MEADOWBROOK PARK PLANNED UNIT DEVELOPMENT (PUD) PLAN

LOCATED IN THE SOUTHEAST 1/4 OF SECTION 8, T14S, R65W, OF THE 6th P.M., EL PASO COUNTY, COLORADO

County File Number: PUDSP20-XXXXX

Kimley»Horn
 2018 KIMLEY-HORN AND ASSOCIATES, INC.
 100 NORTH NEWLAND AVE., SUITE 300
 COLORADO SPRINGS, COLORADO 80903 (719) 453-0180
 NO. _____ REVISION _____ BY _____ DATE _____ APPR. _____
 MEADOWBROOK PARK
 PLANNED UNIT DEVELOPMENT (PUD) PLAN
 PROJECT NO. 096956009
 SHEET 04 OF 11

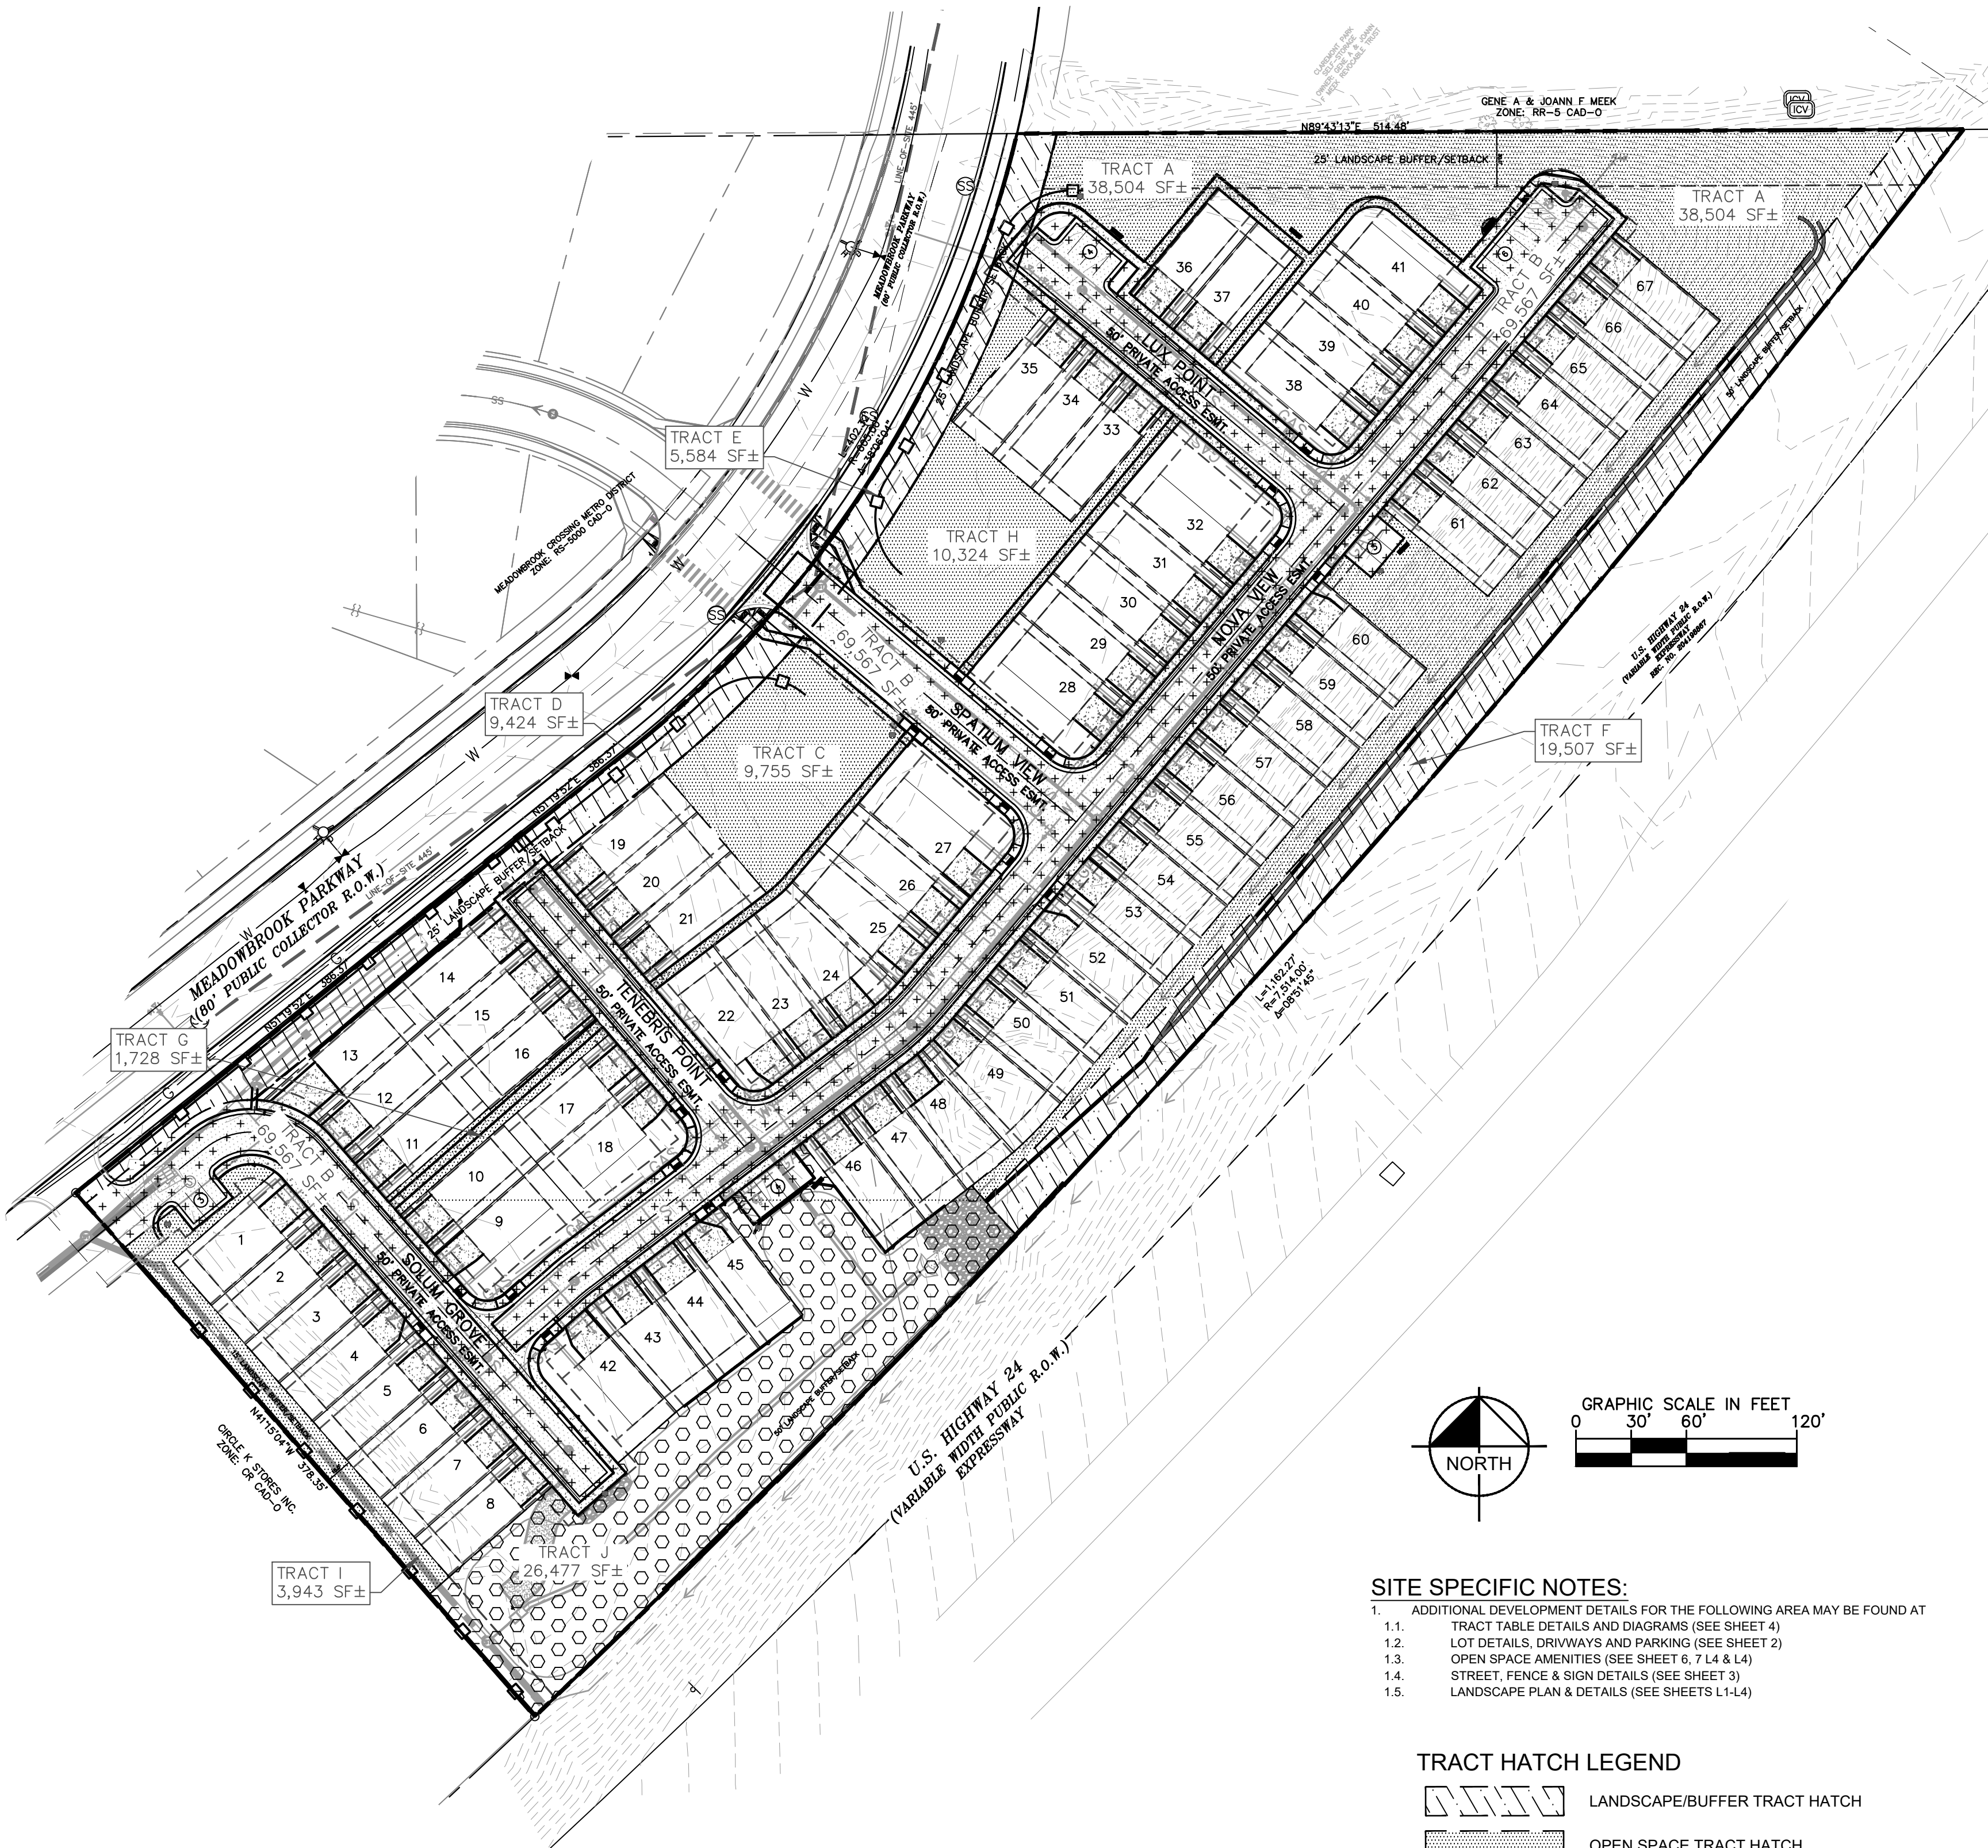
PRIVATE ROAD TRACT
 any parks?
 there must be private road tracts
 break out the open space from the roads; break out the detention pond tract its not for pedestrians... If its landscape tract its not for private roads

widths seem differ but labeled 50'
 PRIVATE ROAD (its in a tract so Road not easement)
 fix overlapping text

Relocate the sidewalk along Meadowbrook parkway to be within the public ROW. The sidewalk shall be located per the County standard Non-Residential Collector Roadway cross section (0.5 ft from edge of the 80ft ROW width). Refer to ECM figure 2-14 and ECM appendix F detail SD2-3.

all lots and tracts shall have a closed boundary depicted graphically and w SF or acreage.

where does one tract start and stop

this needs to be more specific for each track

The parking areas are within the proposed road cross section. Is your intent to indicate that they are outside the paved width of the private roads? Please revise the wording accordingly.

remove building hatch, stated setback sand easements previously

Please verify the scale of the drawing

PROJECT NO.
096956009
SHEET
05 OF 11

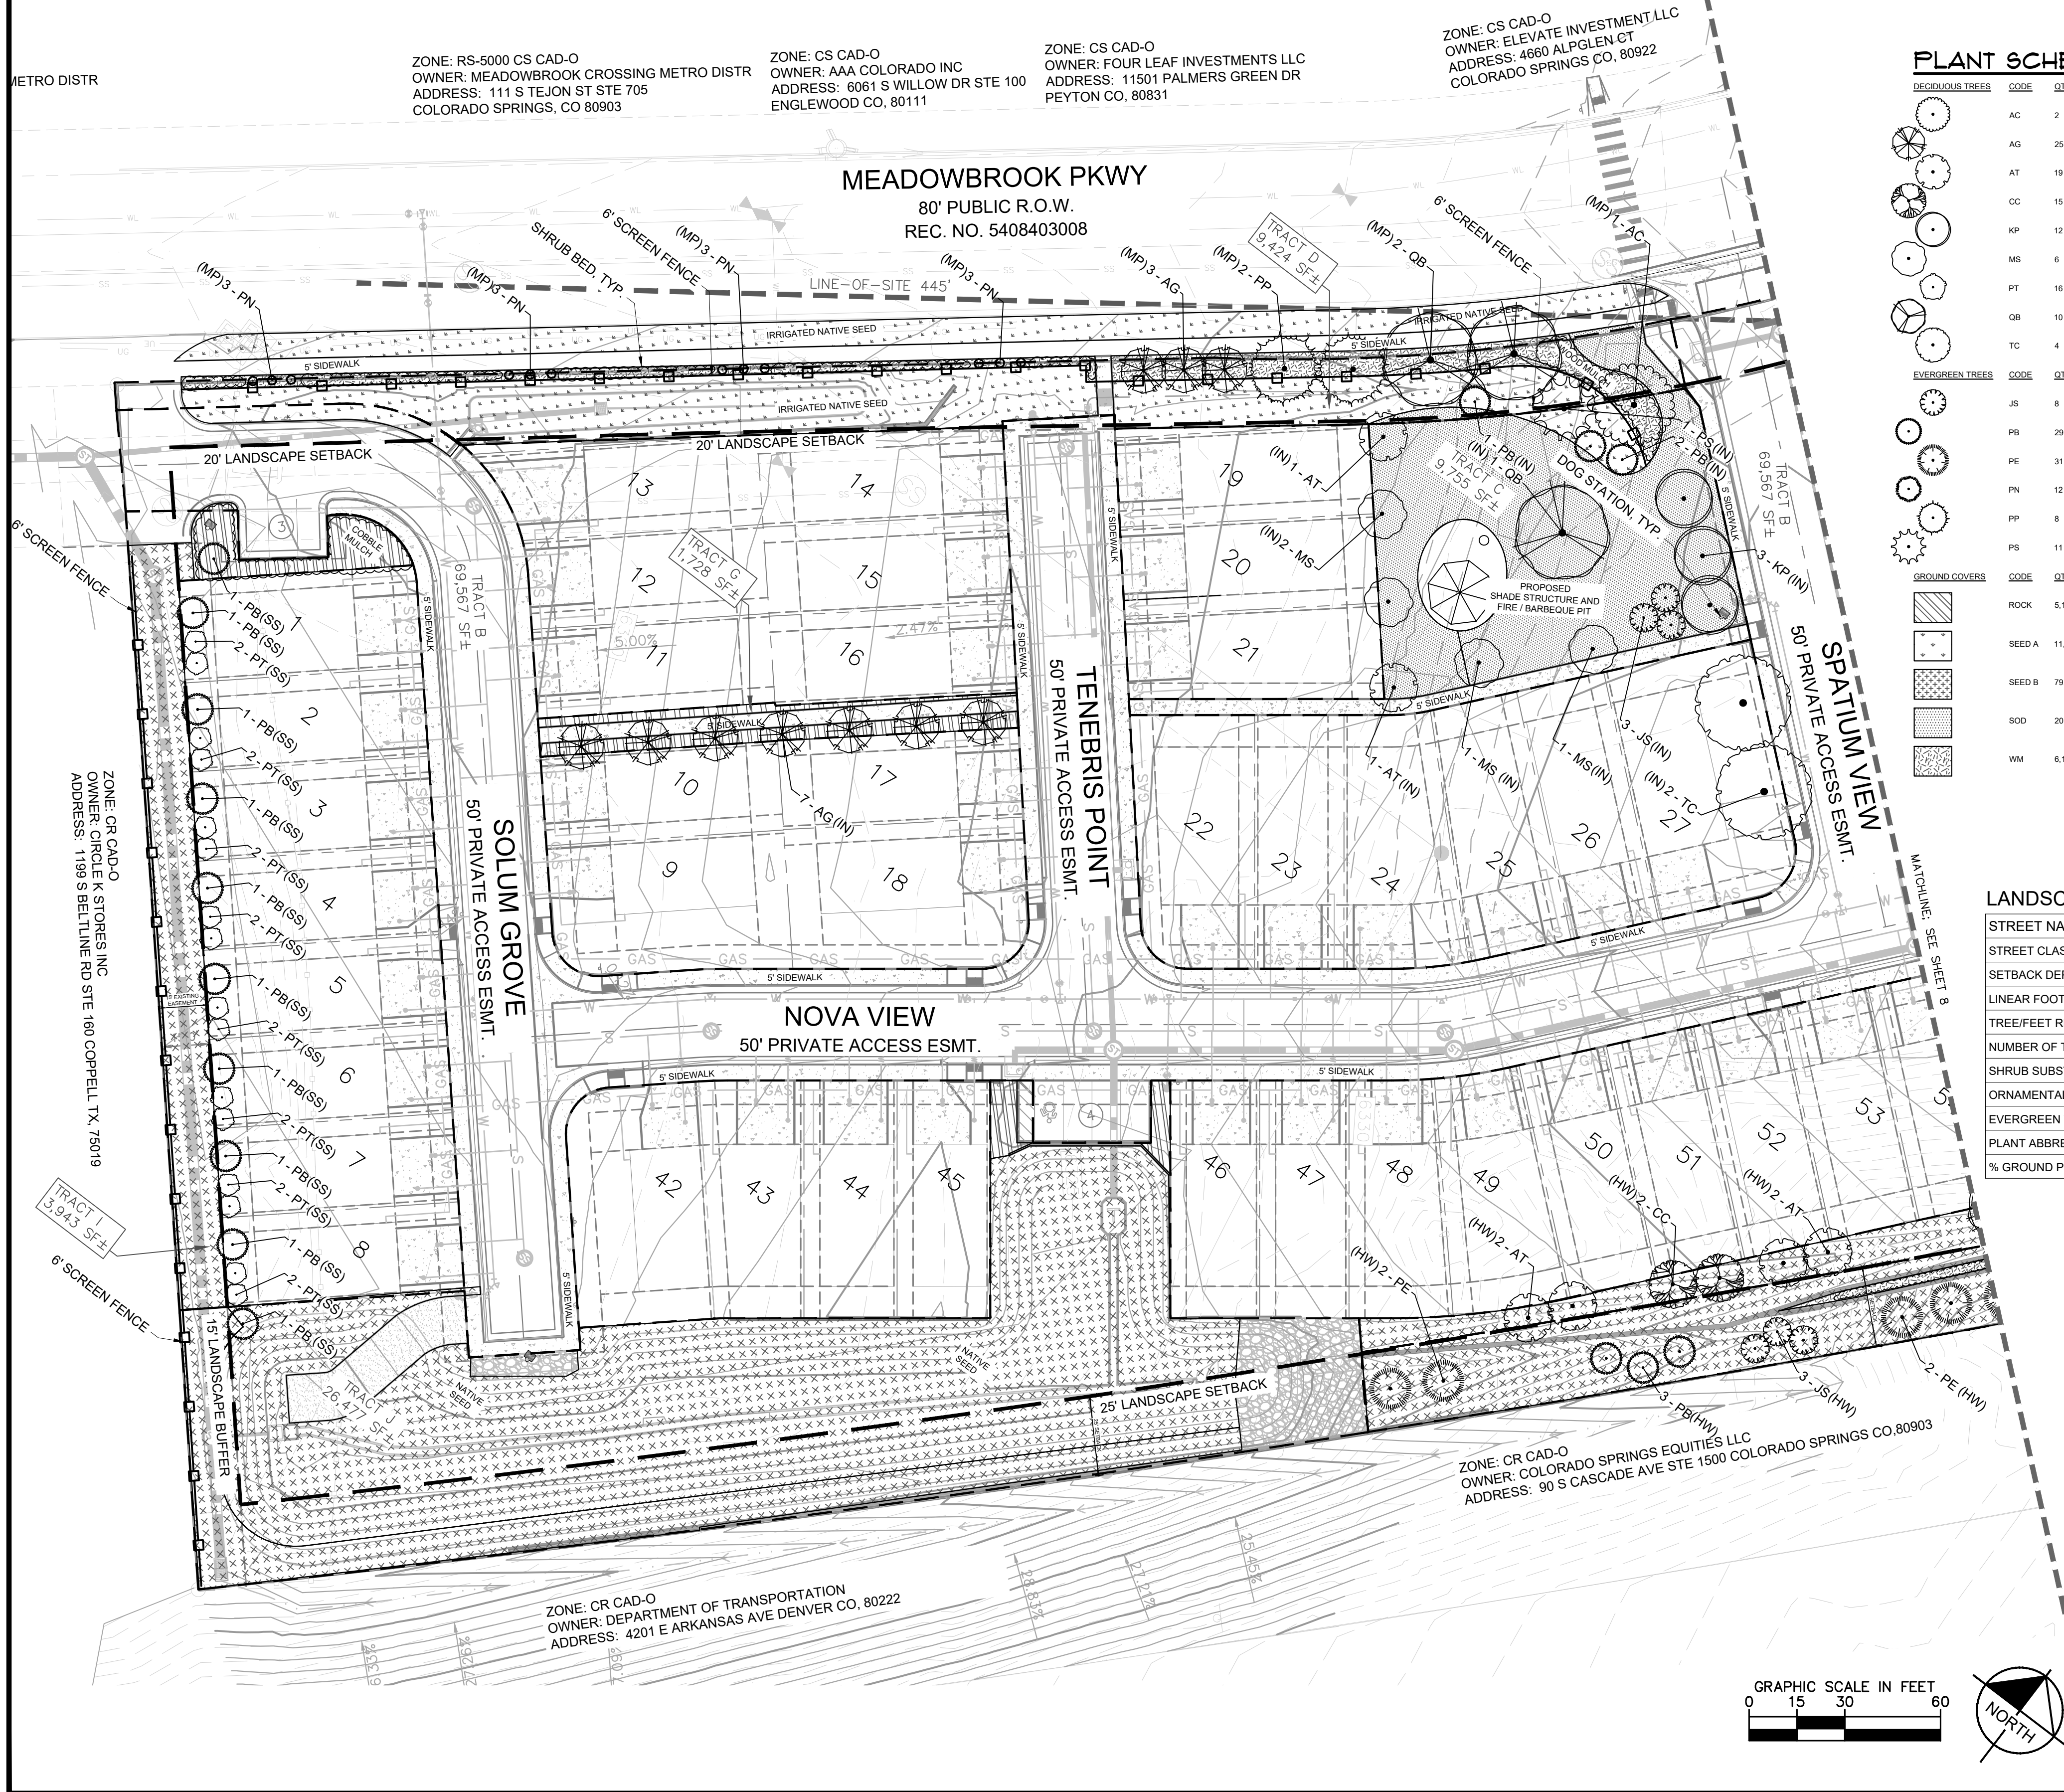
Please show the entirety of this access. Also, please show any existing PED ramps

Please label (sidewalks?) Is this area between the lots an easement, tract?

The legend indicates the curb as type A which is a vertical curb. Note your road sections indicate that all roads have a type C curb with the exception of Nova View. Please revise the drawing to properly indicate the type of curb required at each of the roadways.

Please provide centerline data of the proposed roads.

Please revise as the PED ramp route would be obstructed by the parked vehicles.

Revise pedestrian access ramps to meet County criteria, typical throughout. Refer to County standard details SD 2-42 and SD 2-50.

As indicated in the early assistance meeting, a deviation request will be required for these roads that do not have a cul-de-sac. Please provide a letter of endorsement from the fire district with your deviation request for review and decision by the ECM Administrator.

show the offsite road and label

dimension lots completely- is this alot line? remove the building hatching its not necessary you state setbacks already and makes difficult to see lot line verses easements...

what is the lot line? what are the dashed lines?
